Application number: 2020/90784	
What is the application for?:	Alterations to convert part of existing newsagent into prayer facility
Address of the site or building:	260-262, Wakefield Road, Earlsheaton, Dewsbury, WF12 8AN
Postcode:	WF12 8AN

Figure 1. Proposed internal arrangement of the prayer facility

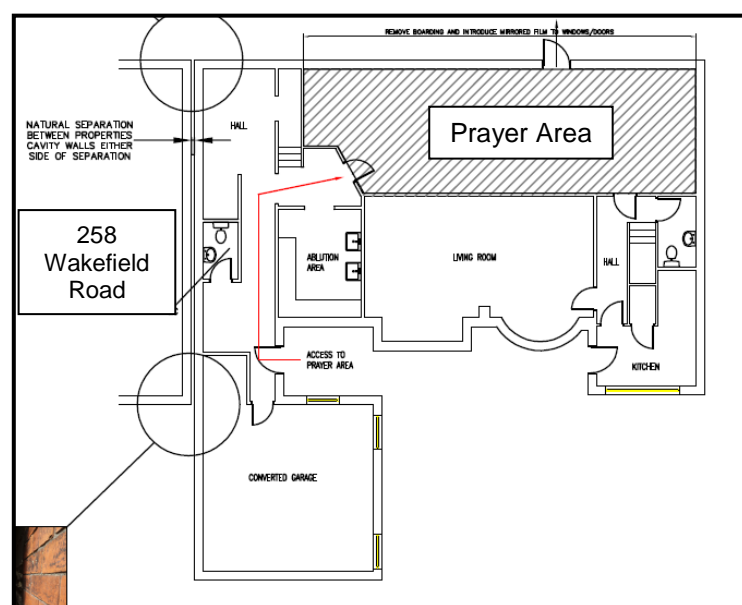
Type of comment: An objection
The proposed site for conversion is a heavily congested area already with traffic consisting of light and heavy goods vehicles. There is inadequate parking accommodations in this area, and on the main Wakefield road, which the empty shop frontage faces has double yellow lines in front of it. The housing estate that wraps round the back of the shop has a overcrowded access We all ready have occasions where th e petrol station itself backs traffic up on the main road.
